DEXUS QUARRYWEST PROJECT (SSD 6801) – SECTION 96 MODIFICATION (MOD 7) – RESPONSE TO SUBMISSIONS

DEXUS Quarry WEST Subtrust (DEXUS) is proposing to modify the development consent for the QuarryWEST Project within the Greystanes Southern Employment Lands. The proposed modification involves changes to the layout of Precincts C and D of the estate. The proposal is described in the Statement of Environmental Effects (SEE) for the proposal dated 18 June 2018.

LA05
P
24 September 2018

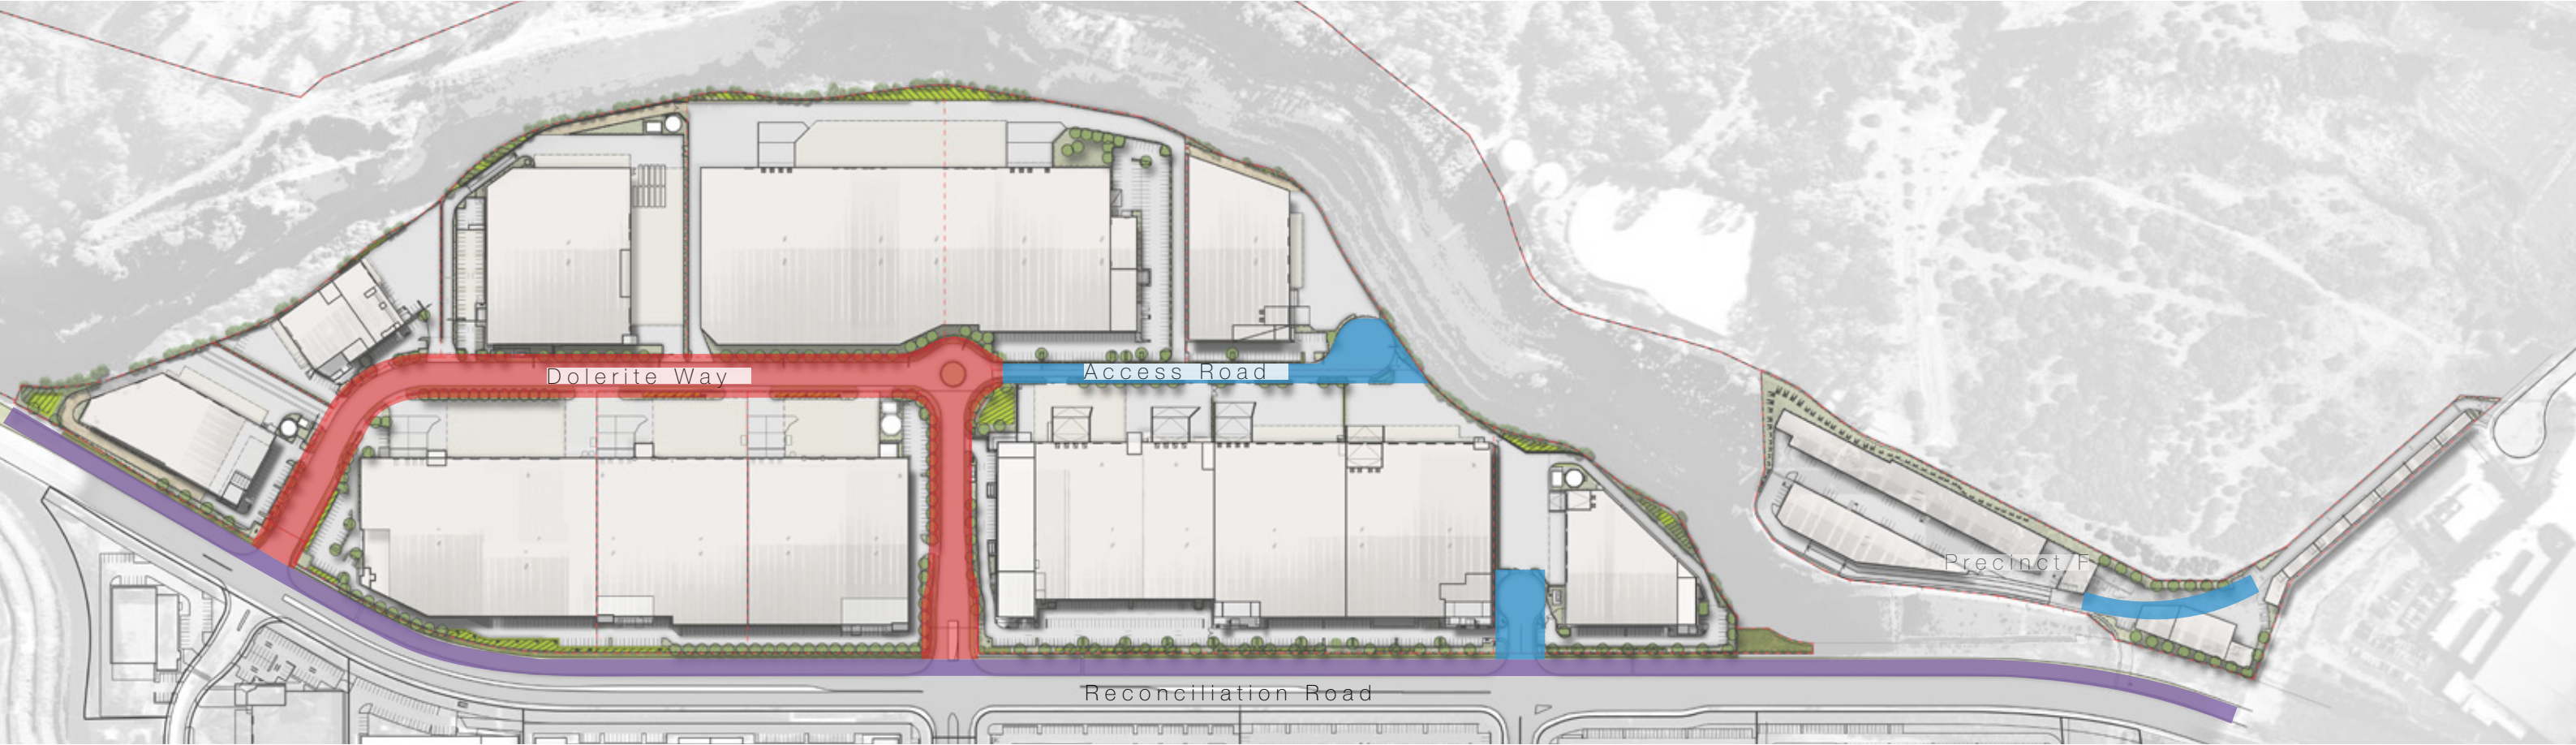
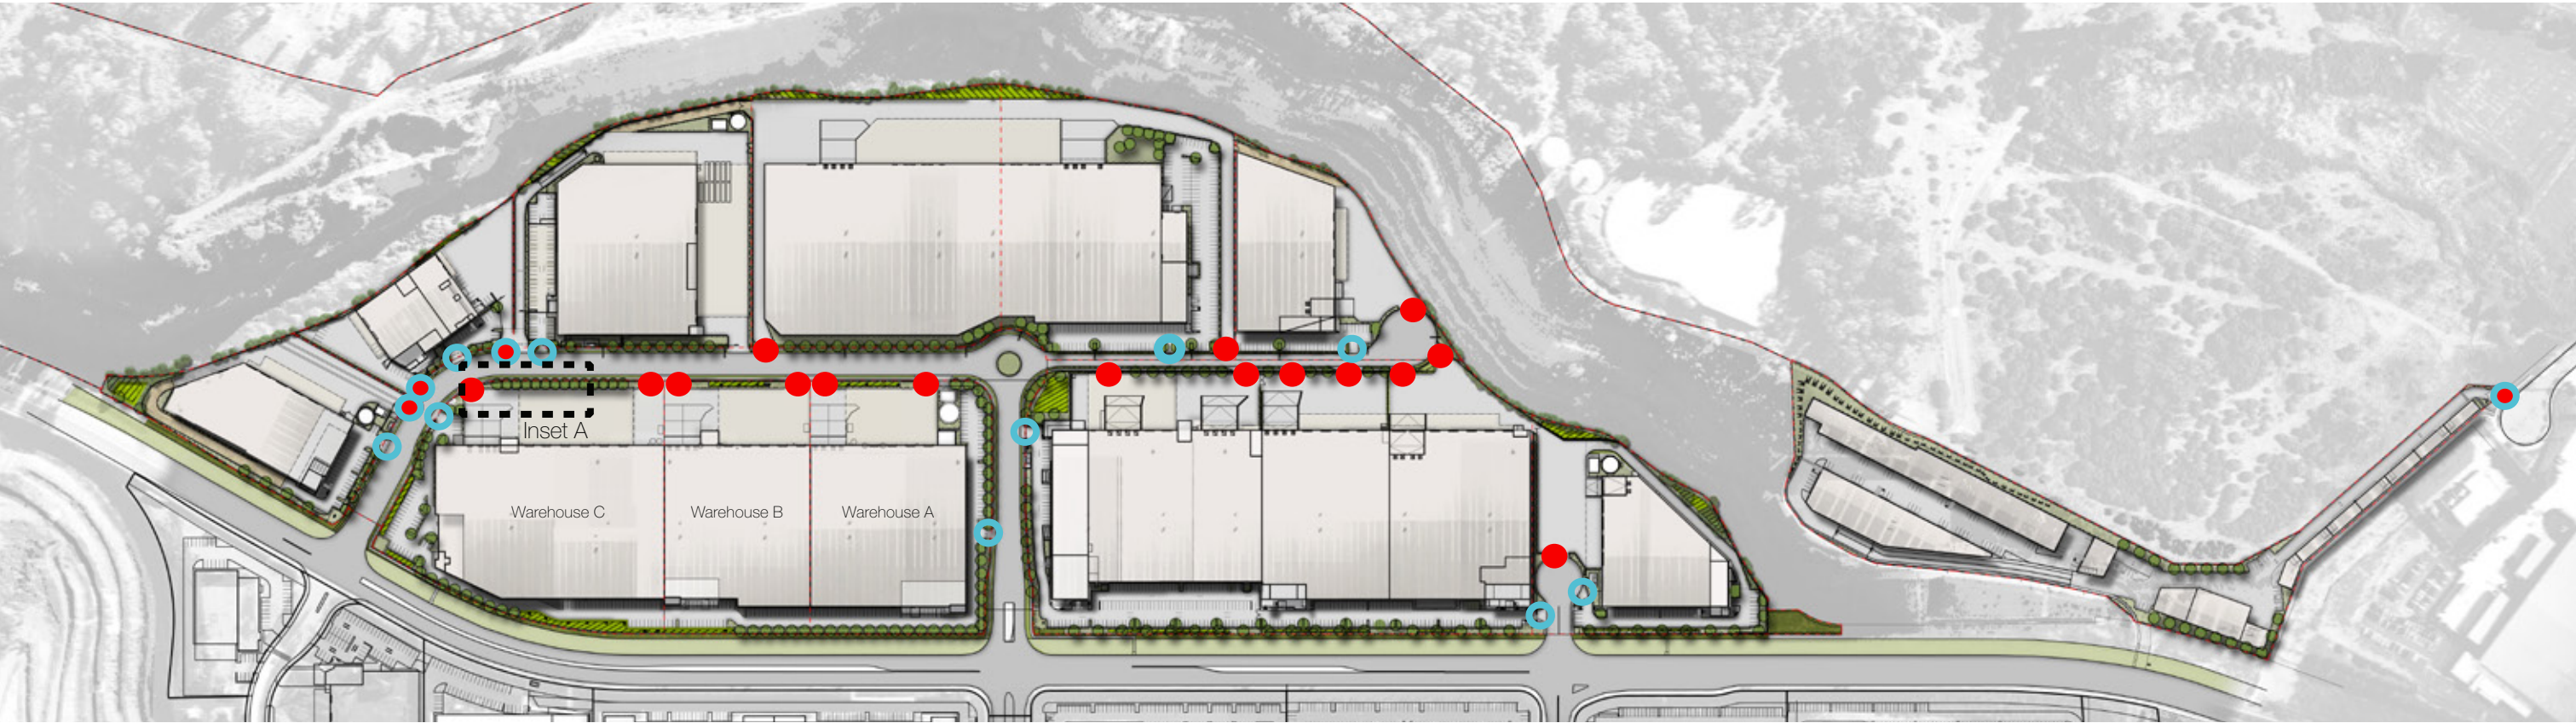
2. Landscaping	The landscape design plans have been amended to provide additional tree plantings along the eastern elevation of Warehouse C, fronting the Prospect Highway (see Appendix B).

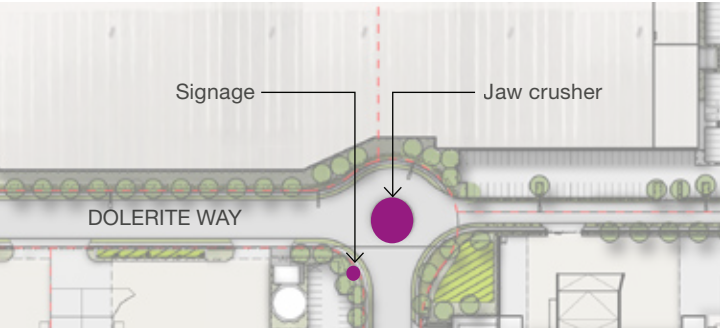
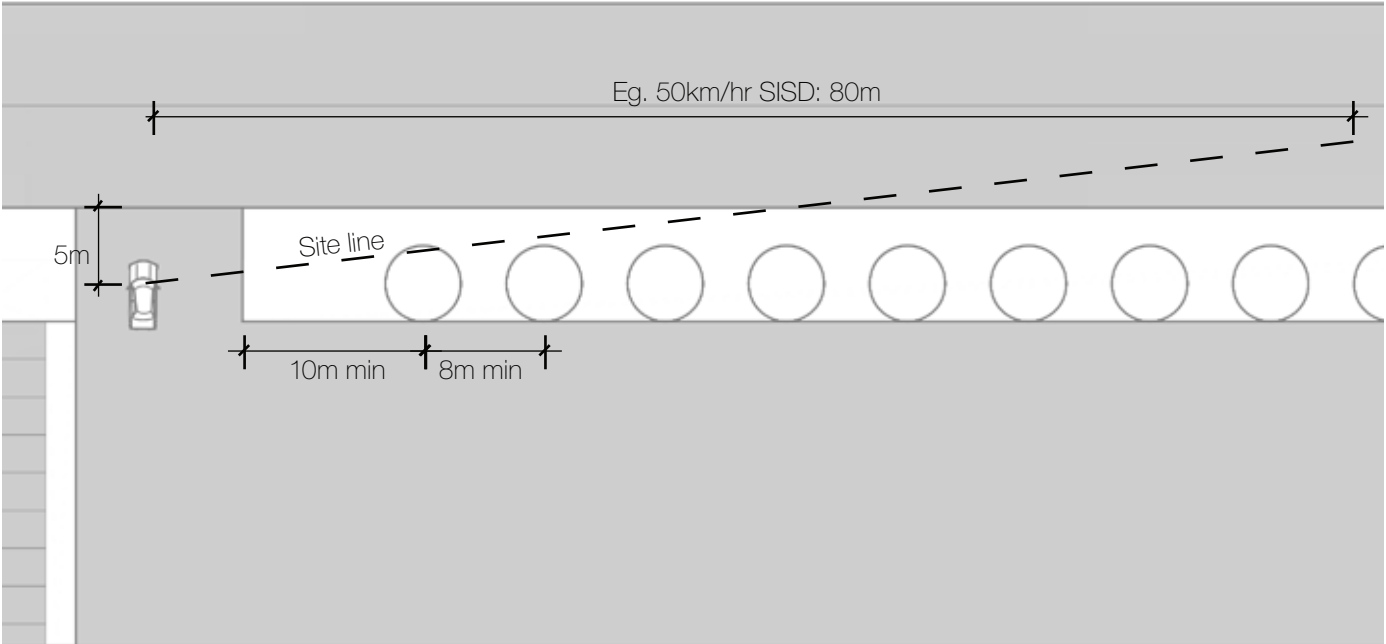
Issue	Response
2. Heritage jaw crusher location and signage	Noted. Council has raised no concerns regarding the jaw crusher location. The recommended information signage would be installed in the location suggested by Council (see Appendix B).
Department of Planning and Environment

Potential locations for vertical element (A) and seating element (B)

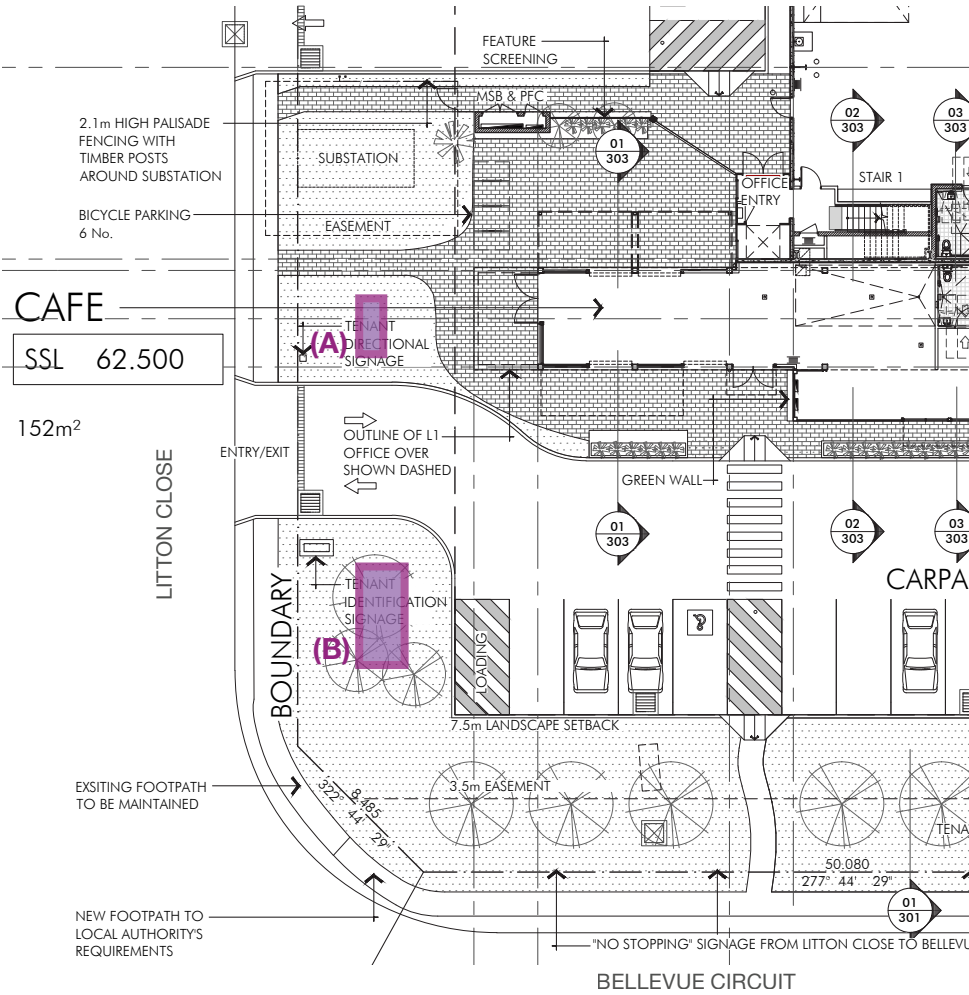
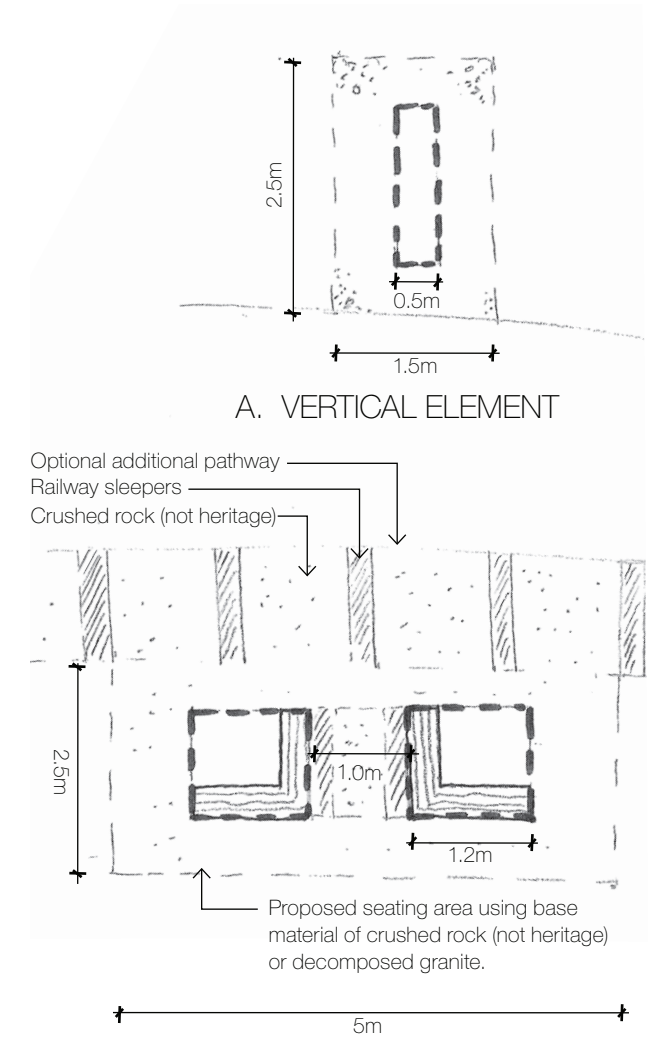
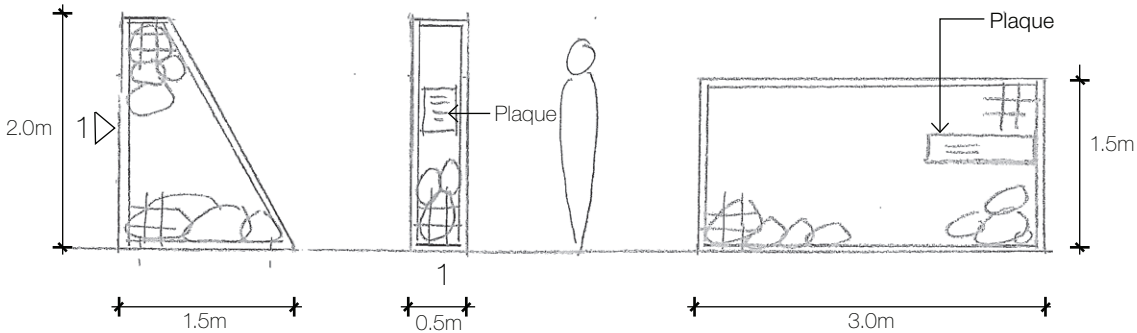
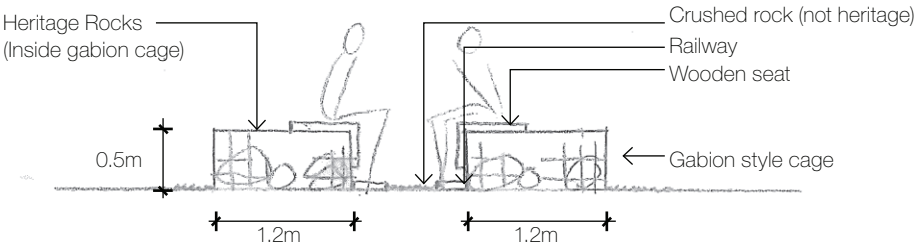
1. Heritage rocks location	Council did not raise any concerns regarding the proposed location of the rocks within a landscape wall feature and/or seating feature near the corner of Prospect Highway and Dolerite Way (in the southern area of the site). However, upon further consideration DEXUS now proposes to locate the wall and/or seating feature within the grounds of the café in QuarryEAST (see Appendix B). This is because the café area is the central meeting place within the QuarryWEST and QuarryEAST estates, and would ensure that the heritage elements receive maximum exposure to the public. The previously proposed location was adjacent to a private car park, with limited public domain amenity. As such, it is considered that the revised location provides a superior planning outcome for the heritage feature.
